From: Amanda Scholes on behalf of Planning.Responses
Sent: 05 May 2017 08:54
To: Planning Scanning
Subject: FW: Planning Consultation on Y/15/17/DOC

Comment from Greenspace

APPLICATION NO: Y/15/17/DOC

Works: imposed under Y/64/16/PL relating to conditions 5-landscape scheme for HGV parking site, 6-landscape scheme along southern boundary, 7-Site Management Plan & 10-light appliances.

Plan 1 – proposed hard and soft landscaping, existing trees and hedgerows to be retained

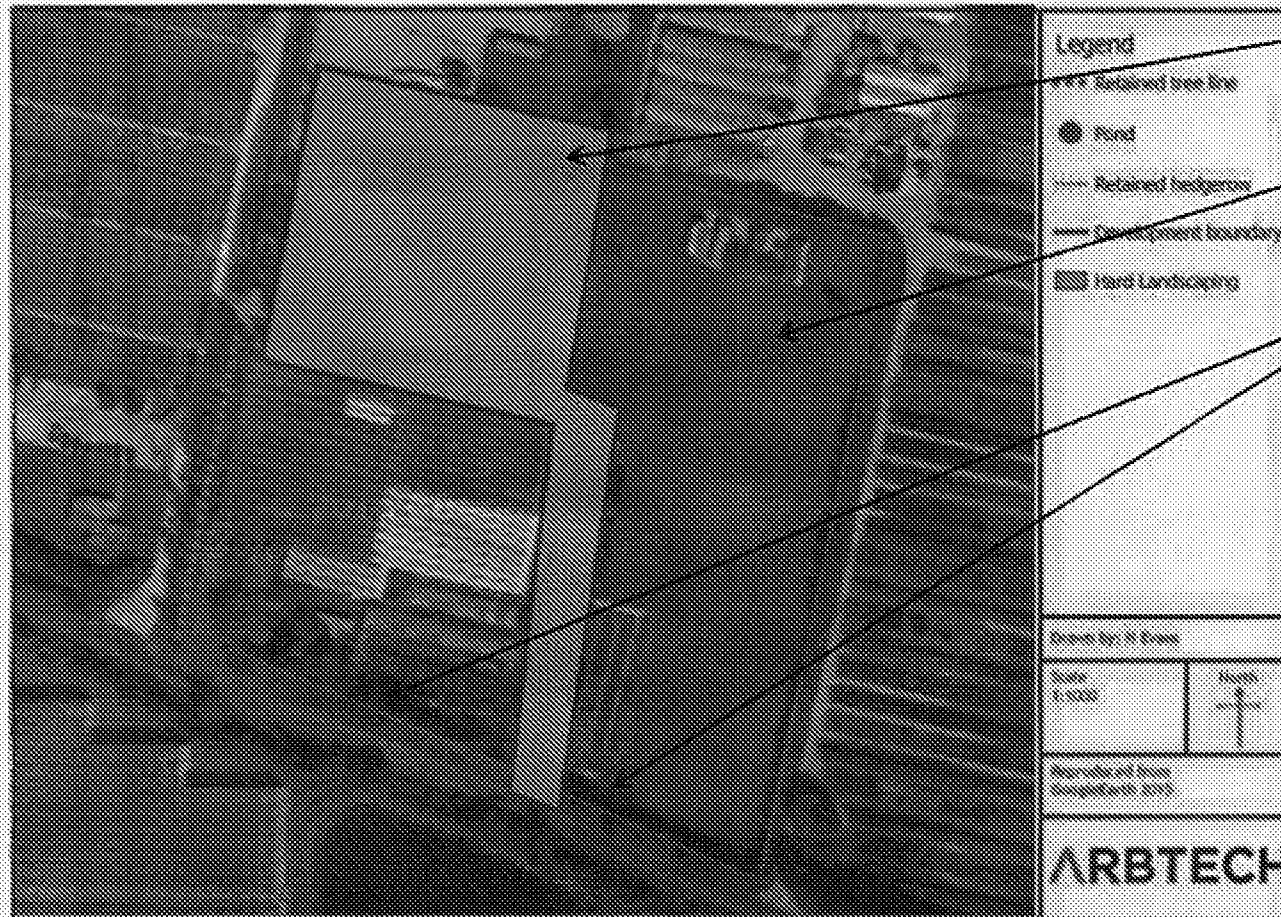
The information submitted within the Arbtech report 02/03/17 provides proposals of a suitable mix of native screen planting mix which would be both suitable for type and location. We would however require that this information is proved in plan form to identify the actual plant numbers being proposed, their locations plotted in plan form and also detail of size at time of planting. There is also some reference to either/or in relation to planting method which needs to be confirmed.
